Transport Response Note

January 2024

NNR House

NNR Global Logistics UK Ltd

Rev	Date
a	Aug 2023 car parking layout updated
b	Nov 2023 application boundary amended

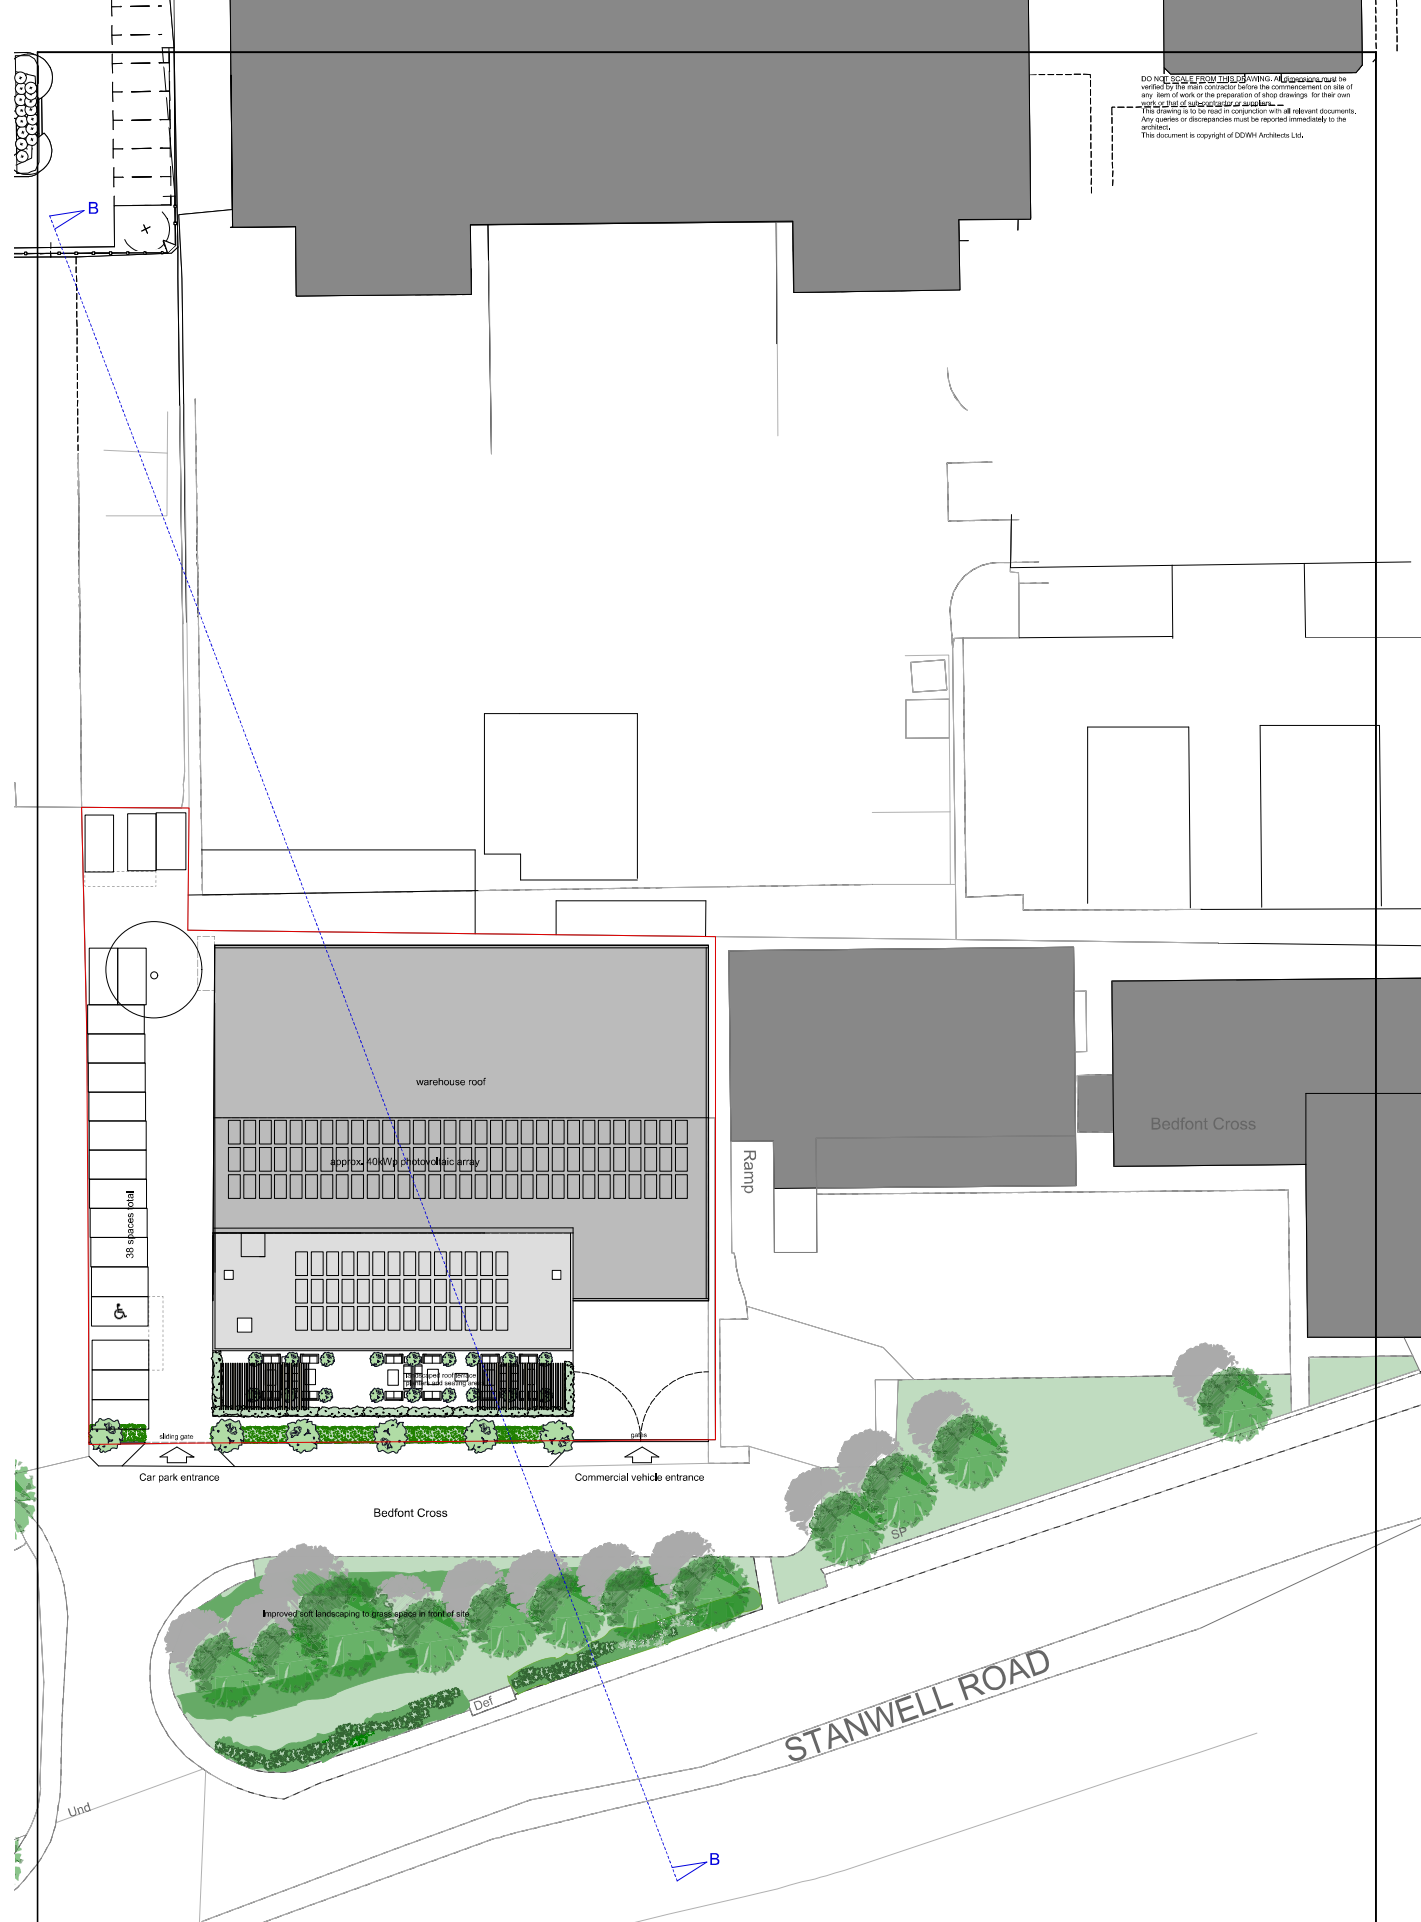
Concerns are also raised regarding pedestrian access to the site. Drawing 237-210 titled Site Plan as Proposed shows the proposed car park entrance with a sliding gate providing access to the car park and main reception, however, the access is not entirely within the red line of the site which is not acceptable. The proposed access will be 4.7m wide which should be widened to 4.8m to concur with Manual for Streets Figure 7.1 which illustrates what various carriageway widths can accommodate. The Transport Statement Paragraph

Drawing 237-210 Site Plan as Proposed shows the proposed car parking layout comprising 38no. parking spaces, however, 17no. spaces are located outside the red line of the site which is not acceptable. The Transport Statement Paragraph 4.26 Car Parking states that

the applicant has a written agreement with the wider land owners (formerly known as BAA plc) to use the strip of land for parking, however, this is not acceptable and the applicant should submit a revised drawing showing the parking within the red line of the site and amending the application form accordingly.

- 2.8 Being under temporary control the client has accepted that the long-term availability of this area remains under third-party control, and that in the unlikely case that the leaseholder requires the land, circa 19 car parking spaces would be lost.

- 2.9 In that case the client retains the option of taking access into the main site car park via the existing eastern access, from where a secondary gate is retained as part of the proposals.

- 5.3 Amendments to the site access points are undertaken in line with these comments, including the widening of the main access point to 4.8m, and slight amendments to the servicing access to permit easier access by HGVs.

Rev	Date
a.	Oct 2023. Warehouse office relocated
b.	Oct 2023. Mesh fence and gate added at end of car park
c.	Oct 2023. Pedestrian gate added, disabled parking, cycle storage and elec charging points amended

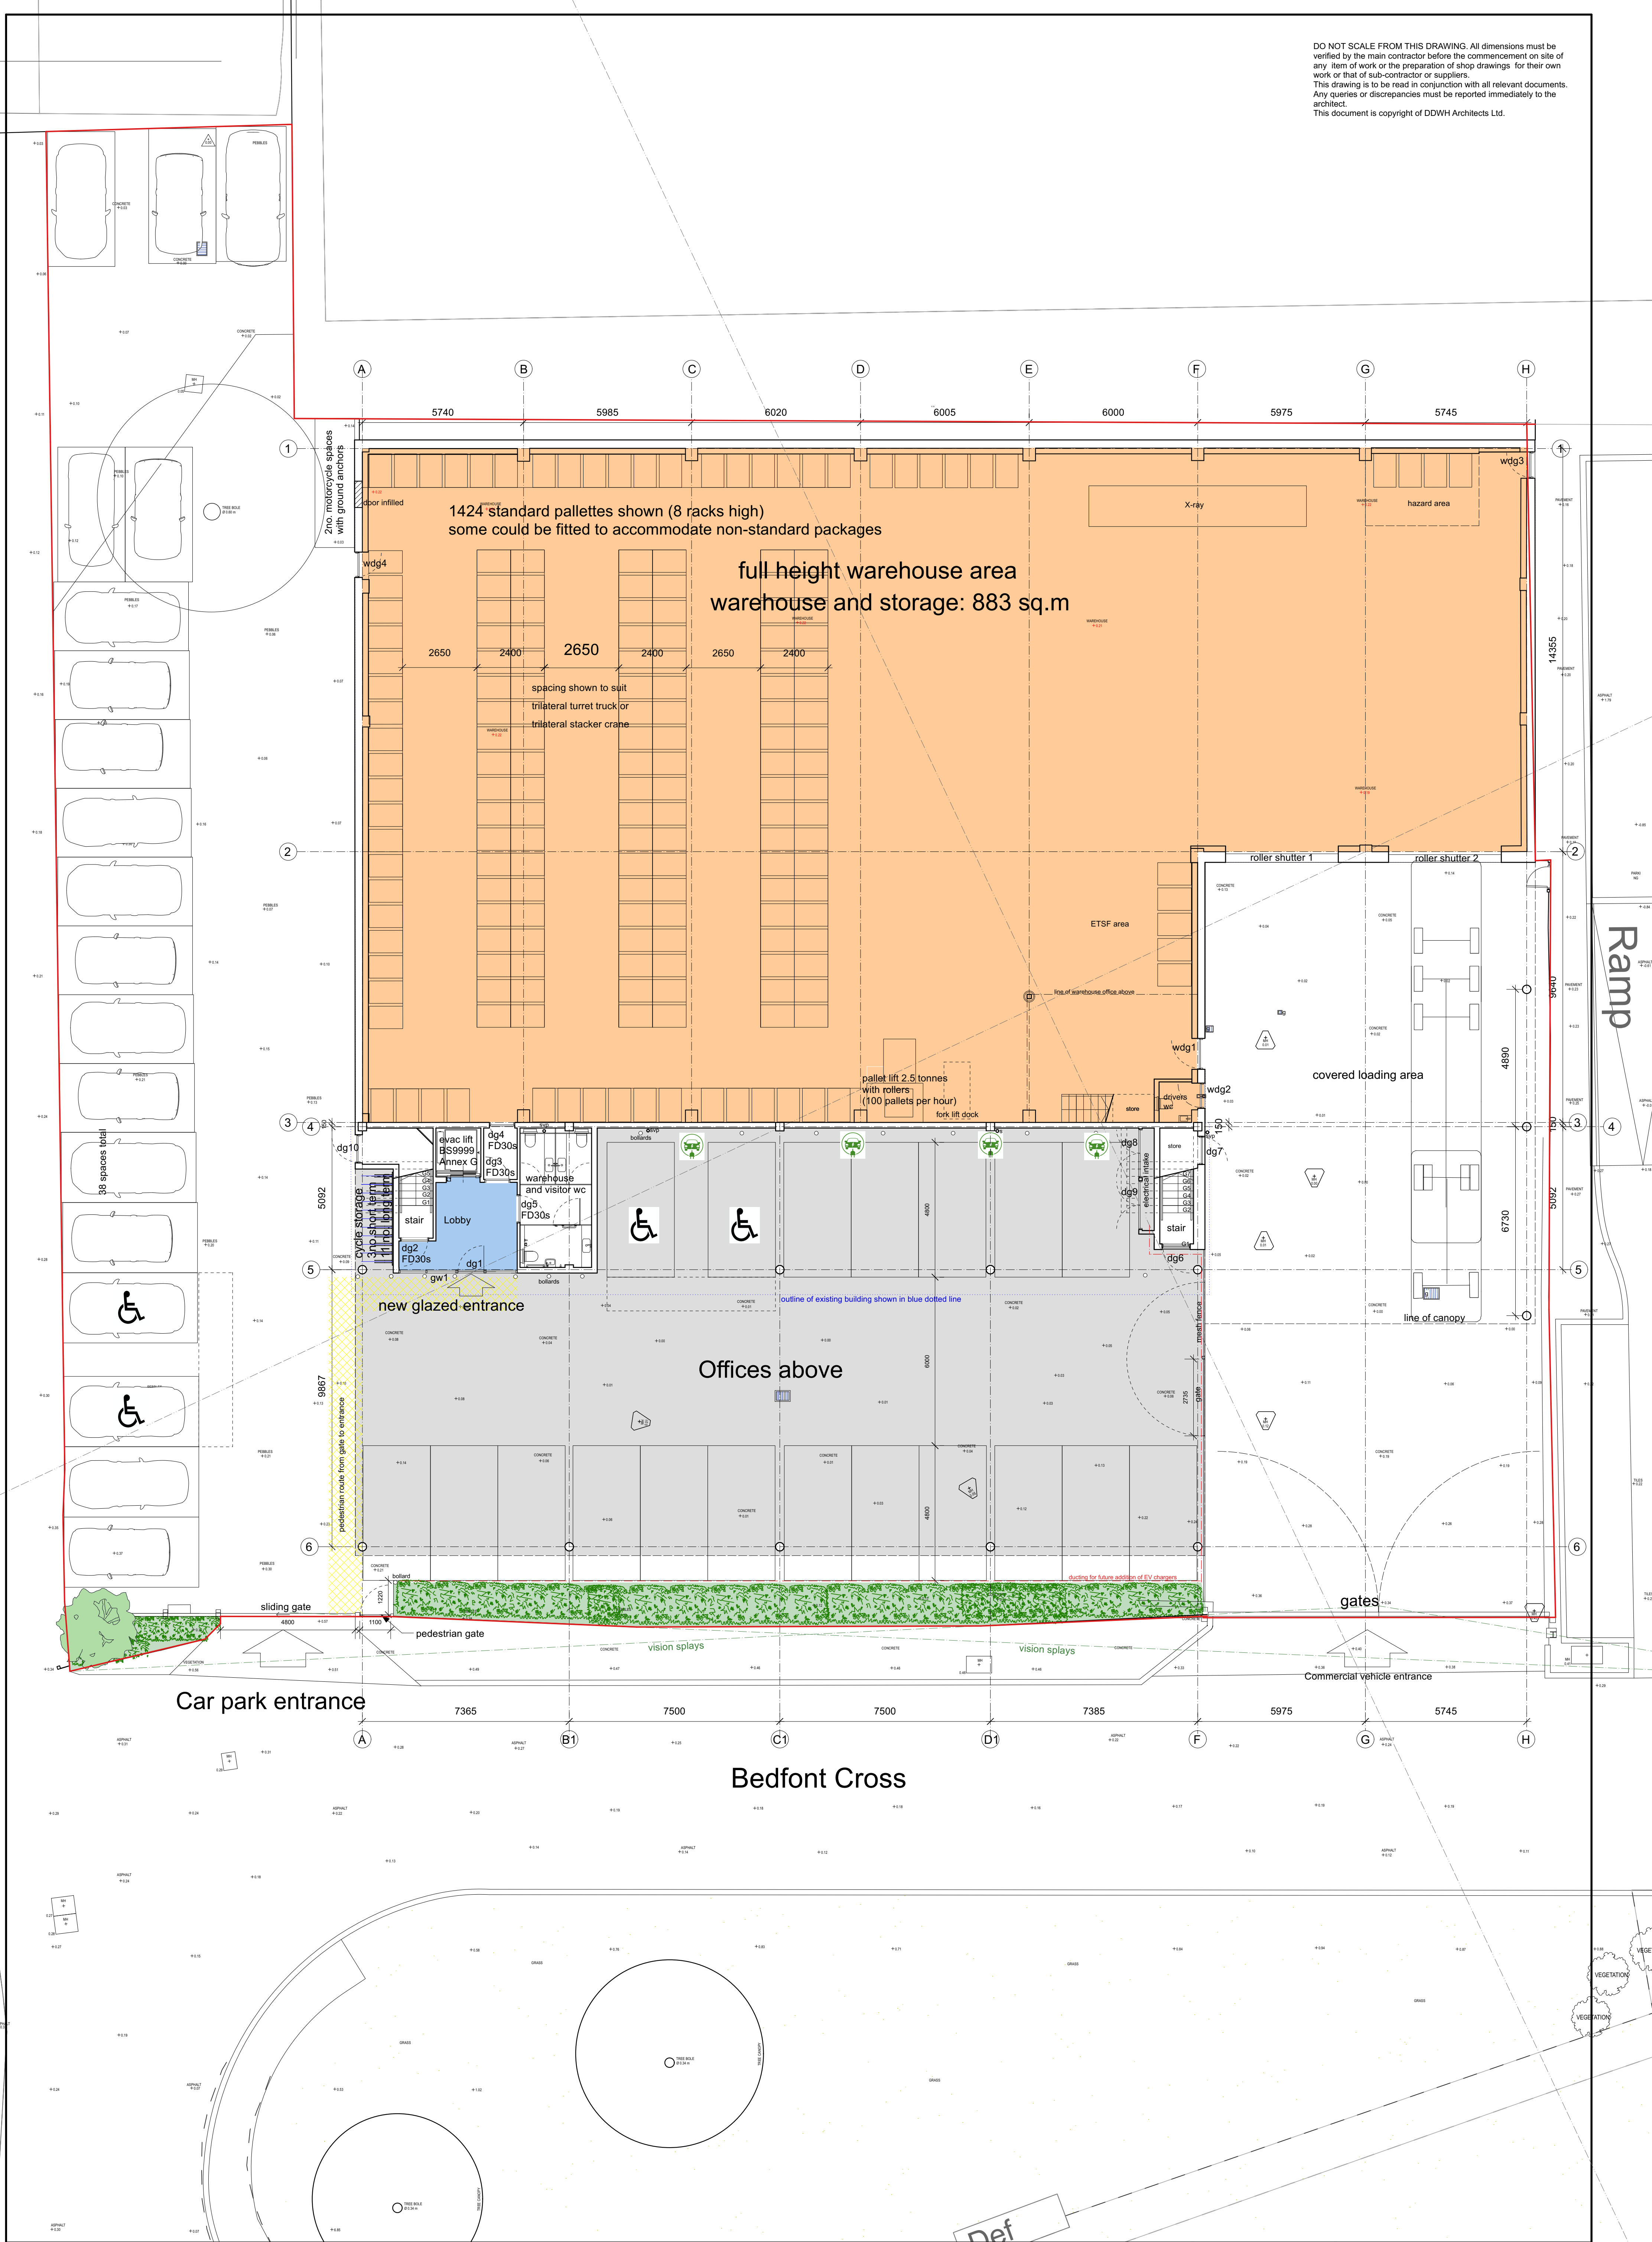
The London Plan Table 10.6 - Non-residential disabled persons parking standards requires that 5% of spaces should be designated bays with a further 5% of spaces being enlarged spaces. The application proposes to provide 6no. designated spaces which will be acceptable, however, 2no. spaces could be provided as enlarged spaces and designated in the future if required.

The LBH Local Plan requires that 5% spaces should be motorcycle spaces. 2no. motorcycle spaces should be provided which should be fitted with ground anchors.

The published London Plan (2021) requires that 20% of car parking spaces should have active EVCPs and 80% of car parking spaces should have passive EVCPs which should be shown on a revised drawing submitted with any full application.

The unreferenced, undated Design and Access Statement Page 9 drawing titled Site Plan as Proposed Showing Parking and Access shows that 9no. long term and 5no. short term cycle parking spaces will be provided which is an acceptable level of cycle parking, however, the long term cycle parking spaces should be relocated closer to the main reception in a position receiving natural surveillance. All long stay cycle parking spaces should be accessible, sheltered, and secure, for short stay parking Sheffield Stands are satisfactory. Full guidance is provided in the Transport for London Cycle Design Standards.

- 4.3 It is noted within the LBH comments that the London Plan proposes the use of both allocated disabled spaces as well as enlarged spaces (for future conversion into disabled spaces).
- 4.4 The comments are agreed, and it is proposed that rather than providing 6 disabled spaces, the car parking area will include 4 disabled spaces and 2 enlarged spaces.
- 4.5 The two disabled parking spaces at the rear of the site are therefore converted into enlarged bays.

- 4.6 LBH also add that the London Plan required 5% provision of Motorcycle spaces.
- 4.7 2 Motorcycle anchors are provided at the rear of the site, near the rear Warehouse access point.

- 4.8 A further comment was also made in regard to Electric Vehicle ('EV') Charging infrastructure, in that 20% should include active Charging Points, whereas the remaining 80% are to include active infrastructure.
- 4.9 This recommendation is agreed, and EV Charging points have therefore been extended to serve 7 parking spaces, with the remaining 31 parking spaces to include the ducting and space necessary to install charger units in the future.

- 5.6 Minor alterations to the site parking areas are also presented within the architect's revised layout. These changes bring the proposals in line with LBH and TfL comments on long-term and short-term cycle parking, as well as motorcycle, disabled, and EV parking spaces.
